Item No. **Report of the Head of Planning, Transportation and Regeneration**

Address 18 LINKSWAY NORTHWOOD

Development: Erection of a detached 7 bed dwelling with basement and habitable roof space to include 4 rear dormers including demolition of existing dwelling, replacement new wrought iron gates and piers and removal of the front boundary brick walls

LBH Ref Nos: **2695/APP/2021/466**

rev.	date	description
scale:	1: 100	A0 date: 12 / 01 / 2021
drawing no:	1366 / P / 10	drawn: FJ
drawing:	PLANNING PROPOSALS COMPARISON PLANS	
project:	LAND AT 18 LINKSWAY, NORTHWOOD, MIDDLESEX, HA6 2XB	
client:	DDA

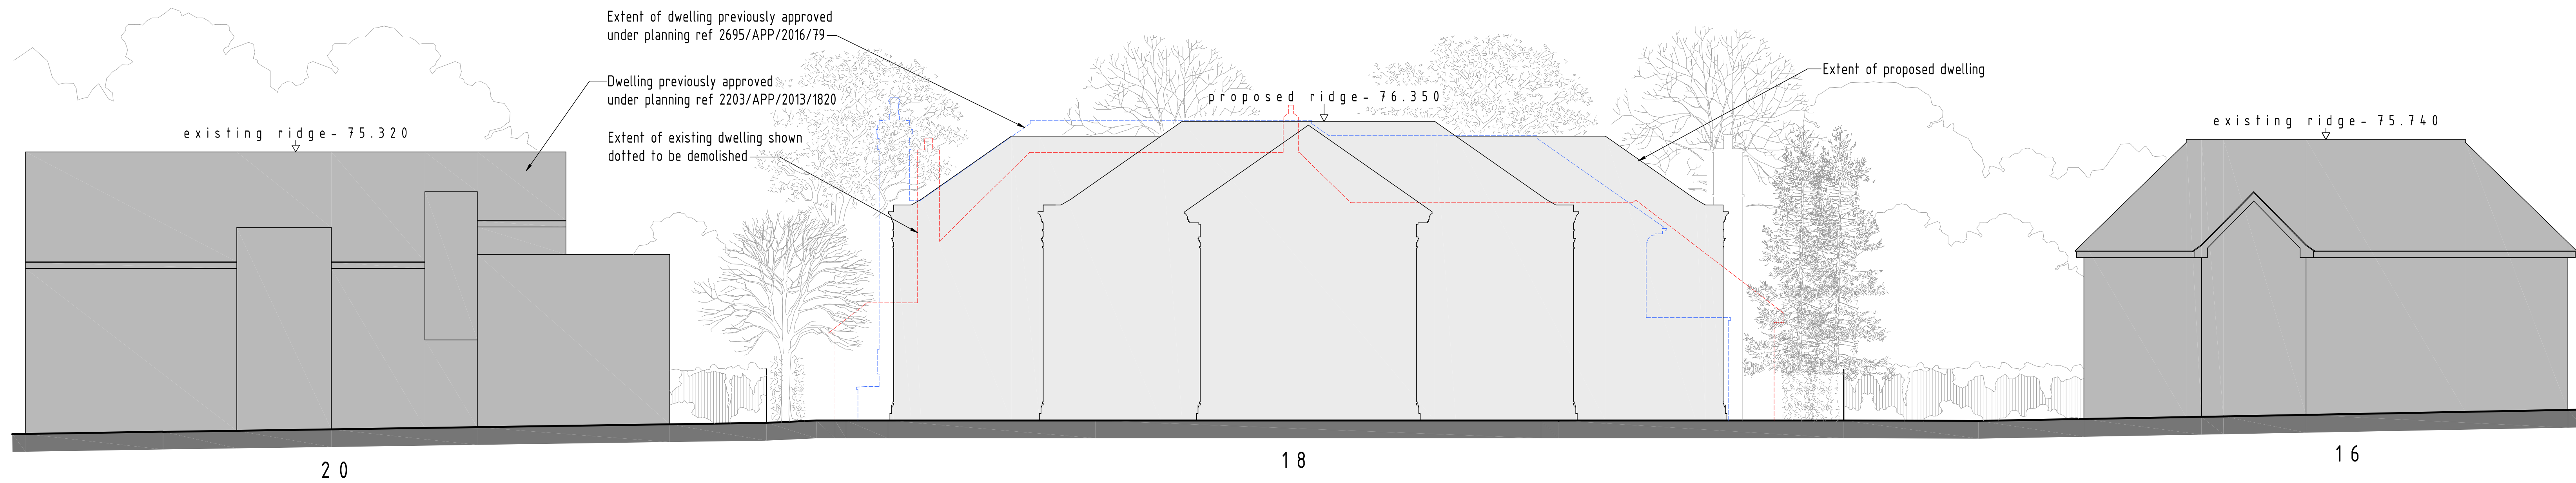
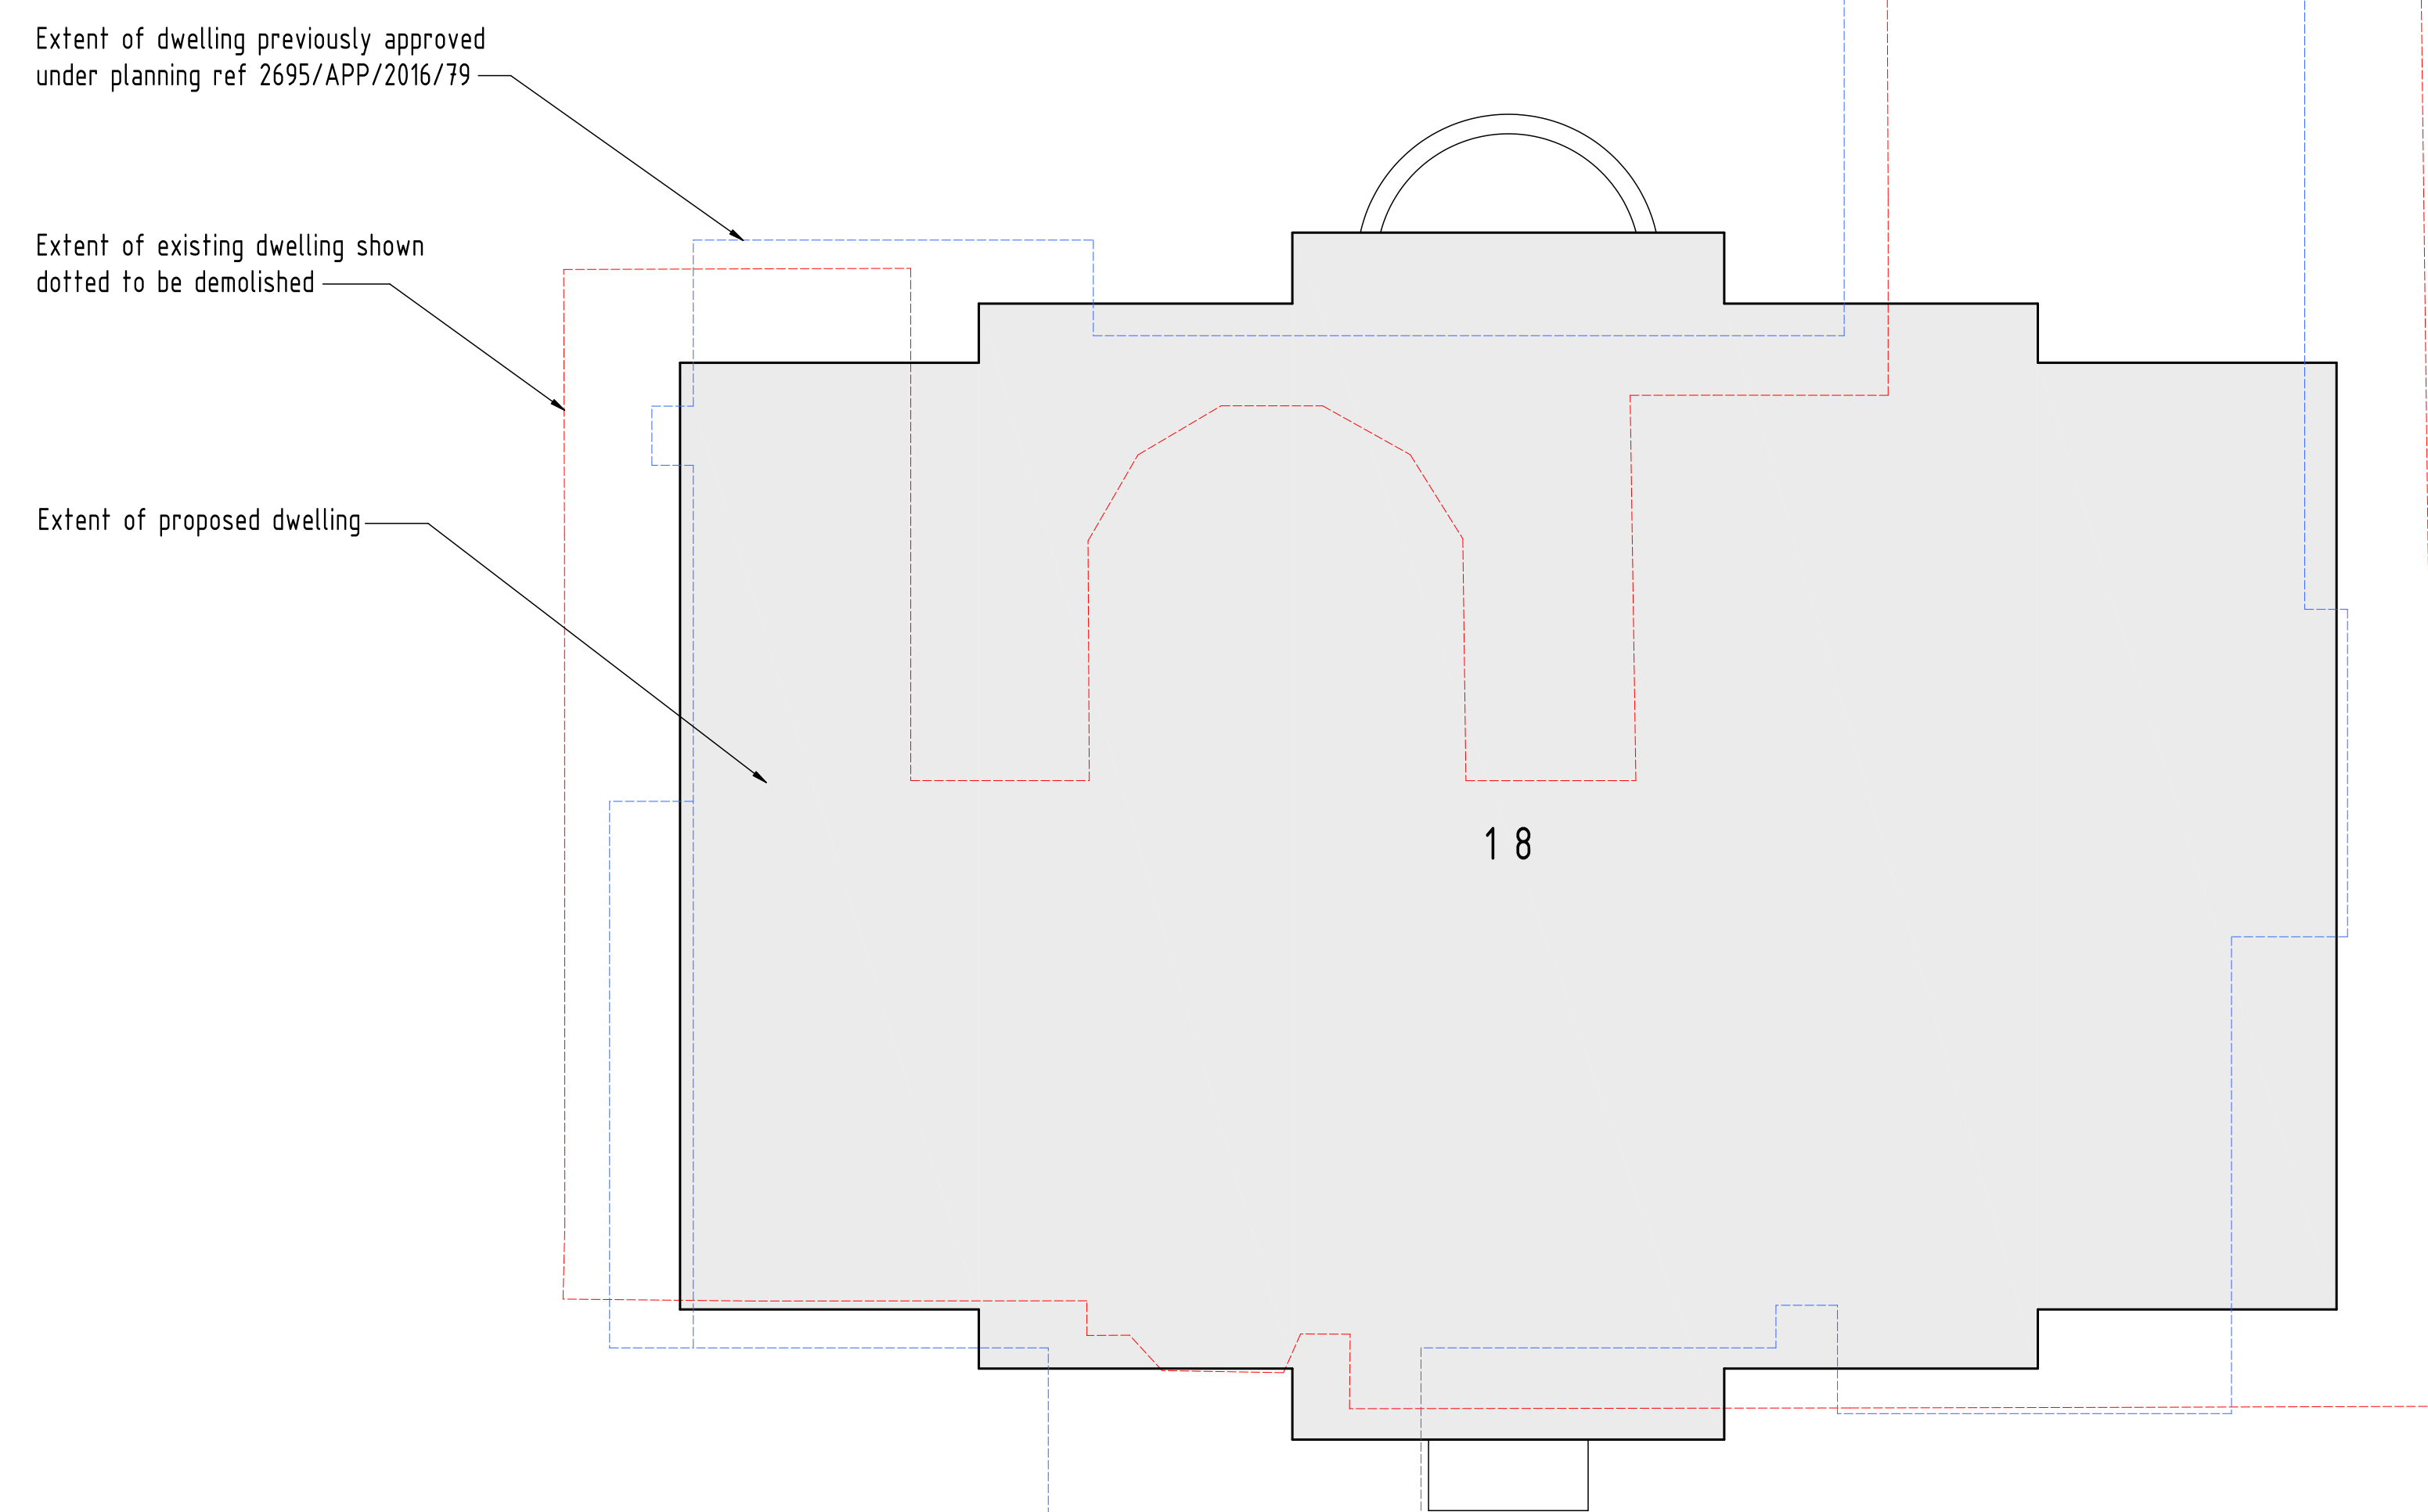
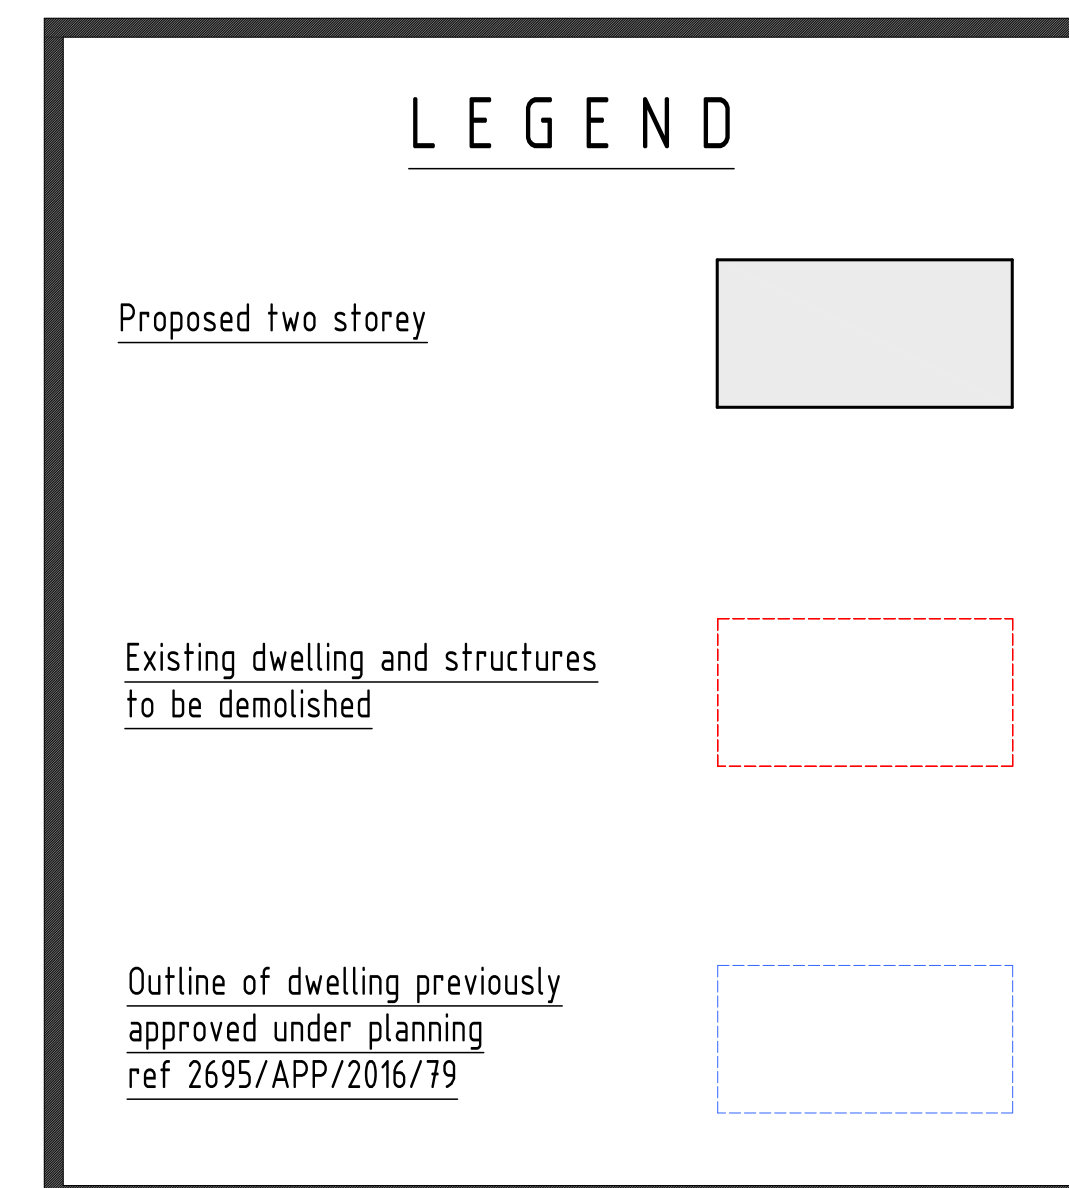
The proposed development would extend across the great width of the site with small gaps retained along the side boundaries. Whilst the footprint may be slightly smaller than the existing building, the scale and bulk of the built form is vast and further accentuated by the design and detailing of the building. The proposed columns elongate the height of the building and the large crown roof exacerbates the bulk of the development.
